Our Reference: SYD16/01201/02  
Department Ref: SSD 7942

**PROPOSED OPEN WATER SURF SPORTS LAGOON FACILITY  
POD 5 P5 CARPARK HILL ROAD, SYDNEY OLYMPIC PARK**

Roads and Maritime has reviewed the submitted Environmental Impact Statement and provides the Department of Planning & Environment (DP&E) with the following comments:

Figure 3.3: Proposed Vehicle Access Arrangements

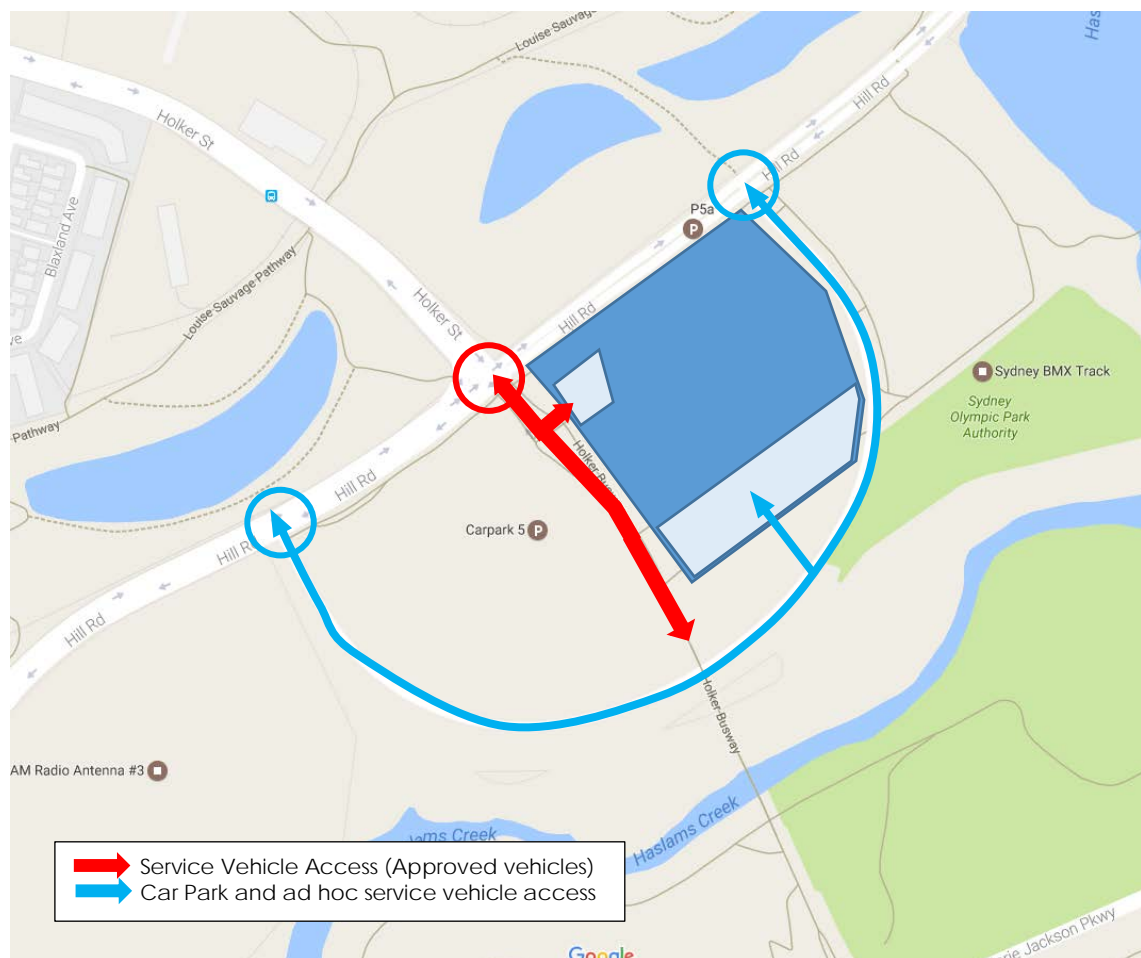
3. The Applicant should provide further information regarding the proposed access management via the Holker Street Busway for service vehicles and staff parking. This would include providing information on the signage requirements and enforcement procedures to prevent the use of the busway for general traffic. This shall be at no cost to Roads and Maritime.

Figure 5.1: Emergency Vehicle (Ambulance) Standing Areas and Access

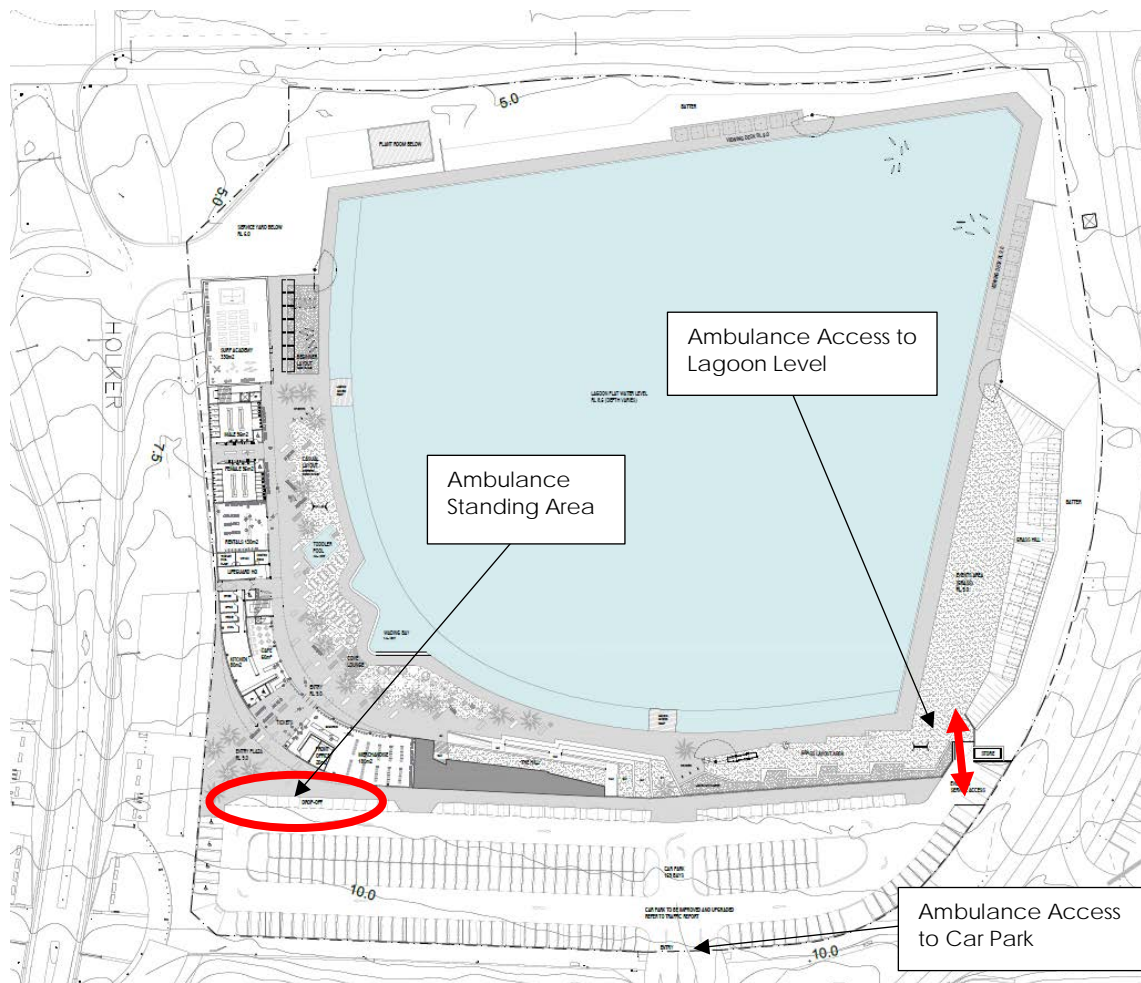
5. Swept path analysis of ambulance vehicles entering and exiting the subject site from the car park access should be provided. It is unclear as to whether the existing car park access could accommodate emergency ambulance vehicle movements.
